**WELWYN HATFIELD BOROUGH COUNCIL  
EXECUTIVE DIRECTOR - PLANNING, PUBLIC PROTECTION AND GOVERNANCE**

**DELEGATED APPLICATION**

**Application No:** 6/2019/2944/HOUSE  
**Location:** 28 Bradgate Cuffley Potters Bar EN6 4RL  
**Proposal:** Erection of a part single storey, part two storey rear extension  
**Officer:** Mr Tom Gabriel

**Recommendation:** Granted

DRAWING NO. 1711 - 202 A

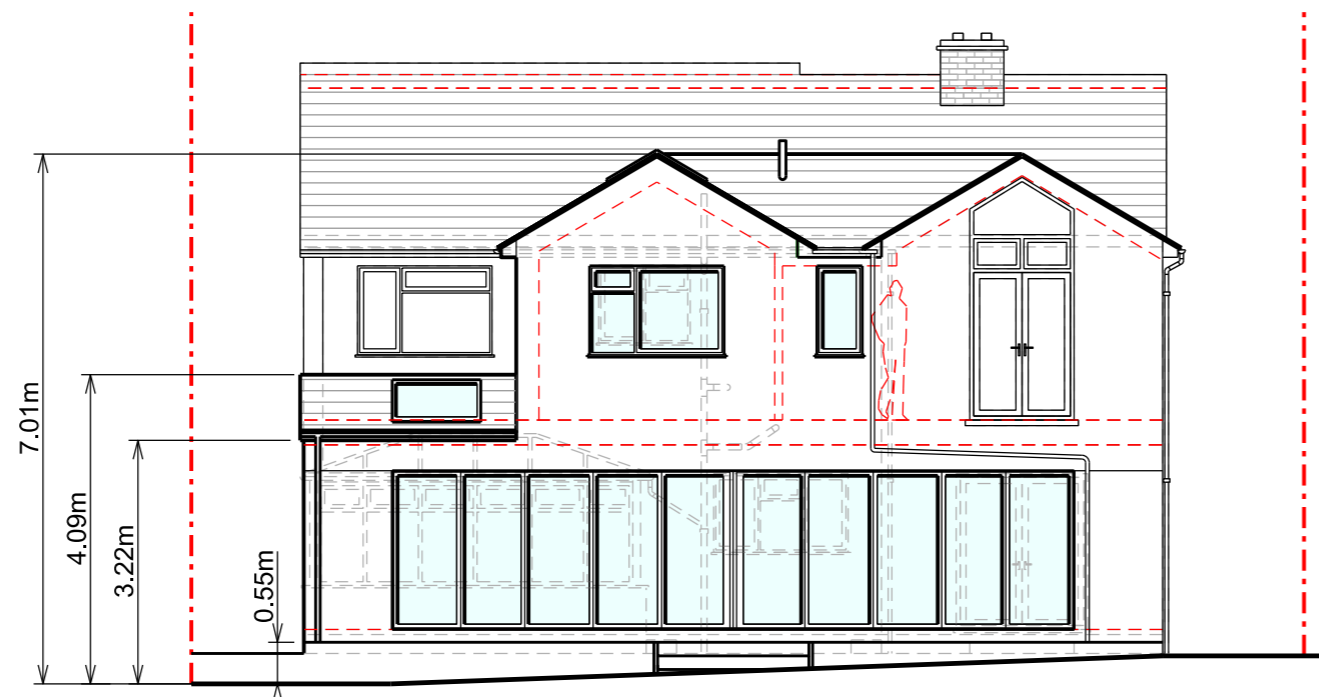
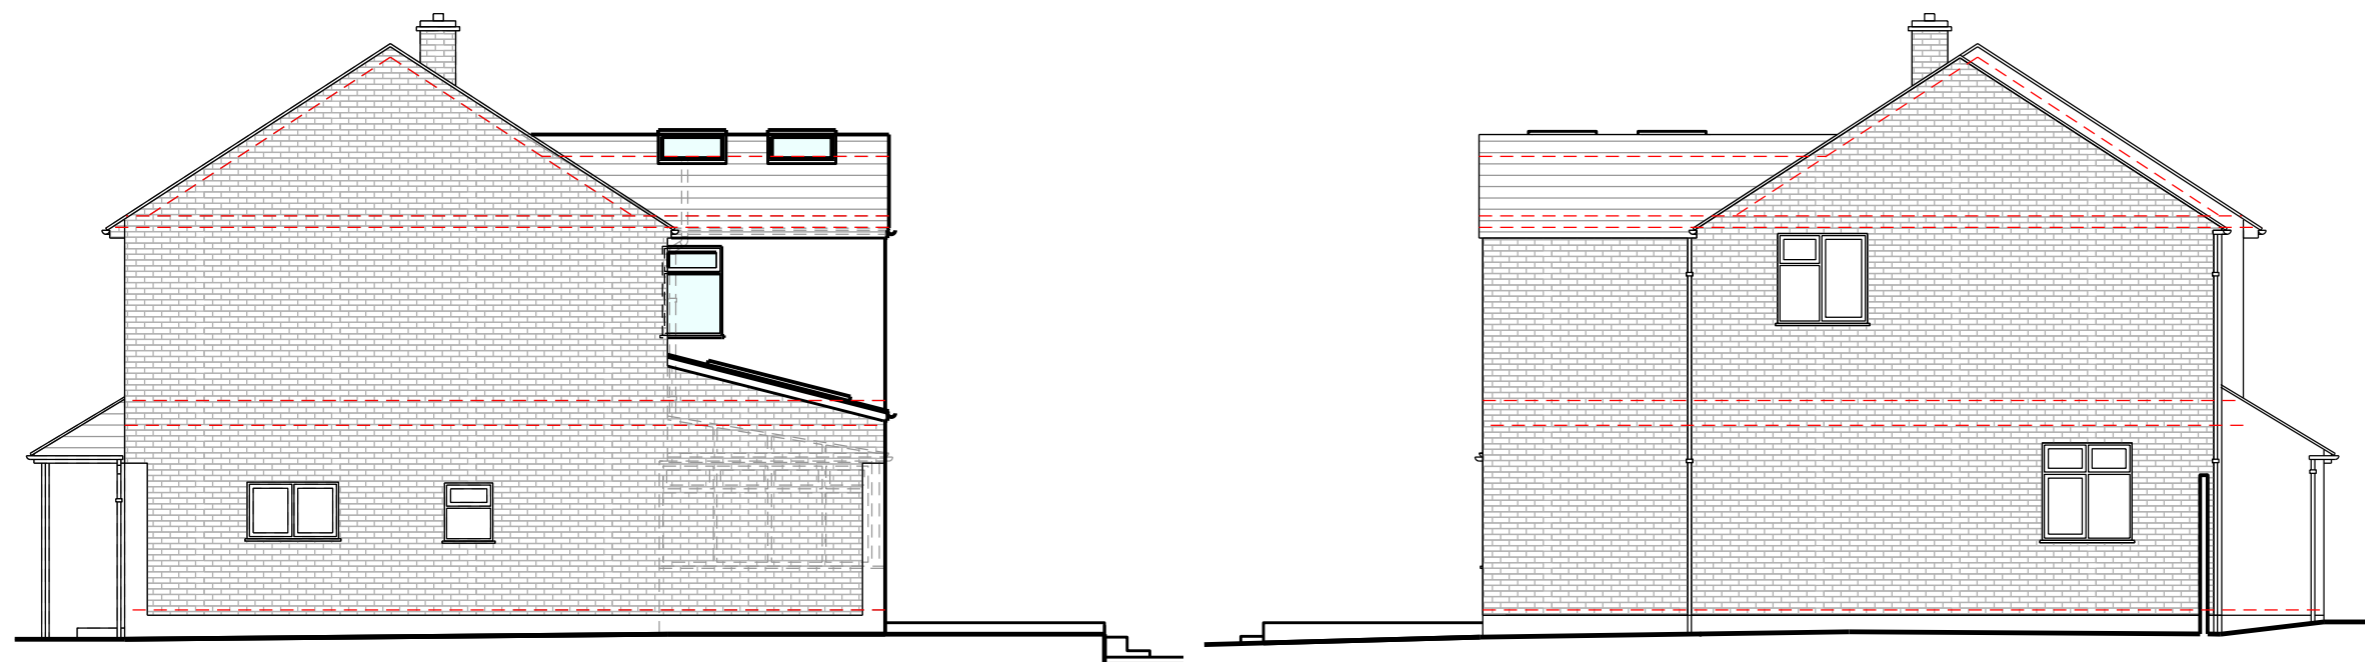
<b>Welwyn Hatfield Draft Local Plan</b> SP9 SADM11 SADM12
<b>Main Issues</b>
<b>Is the development within a conservation area?</b>
<input type="checkbox"/> Yes <input checked="" type="checkbox"/> No
<b>Would the significance of the designated heritage asset be preserved or enhanced?</b>
<input type="checkbox"/> Yes <input type="checkbox"/> No <input checked="" type="checkbox"/> N/A <b>Comment</b> (if applicable):
<b>Would the development reflect the character of the area?</b>
<input checked="" type="checkbox"/> Yes <input type="checkbox"/> No <b>Comment</b> (if applicable): A number of the nearby dwellings have had single and/ or two storey rear extensions of a variety of sizes such that the resultant dwelling at 28 Bradgate would not be incongruous within the context of the area.
<b>Would the development reflect the character of the dwelling?</b>
<input checked="" type="checkbox"/> Yes <input type="checkbox"/> No <input type="checkbox"/> N/A <b>Comment</b> (if applicable): The extension would have a pitched roof which would match the pitch of the existing first floor rear projection. Whilst it would have a crown roof that and additional gable, given its location to the rear it is not considered that it would have such an undue impact to warrant refusal of the application in this regard. With matching materials of construction, the extension would relate to the dwelling well.

<b>Would the development maintain the amenity of adjoining occupiers?</b> (e.g. privacy, outlook, light etc.)
<input checked="" type="checkbox"/> Yes <input type="checkbox"/> No <input type="checkbox"/> N/A <b>Comment</b> (if applicable): The extension would be screened from the neighbouring dwelling at 30 Bradgate by the existing first floor rear projection at the dwelling and would be sited sufficiently far from 26 Bradgate to not have an adverse impact upon either of the dwellings.  A window is proposed in the side elevation serving the bathroom. Subject to this being obscure glazed and non opening below 1.7m, which can be conditioned, there would be no undue impact to neighbour privacy.
<b>Would the development provide / retain sufficient parking?</b>
<input checked="" type="checkbox"/> Yes <input type="checkbox"/> No <input type="checkbox"/> N/A <b>Comment</b> (if applicable):
<b>Conclusion</b>

1. The brickwork, roof tile, bond, mortar, windows, detailing, guttering, soffits and other external decorations of the approved extension/alterations must match the existing dwelling/building in relation to colour and texture.

- The upper floor window located in the wall of the side elevation of the rear extension hereby approved must be obscure-glazed and non-opening unless the parts of the window which can be opened are more than 1.7 metres above the floor of the room in which the window is installed, and shall be retained in that form thereafter.
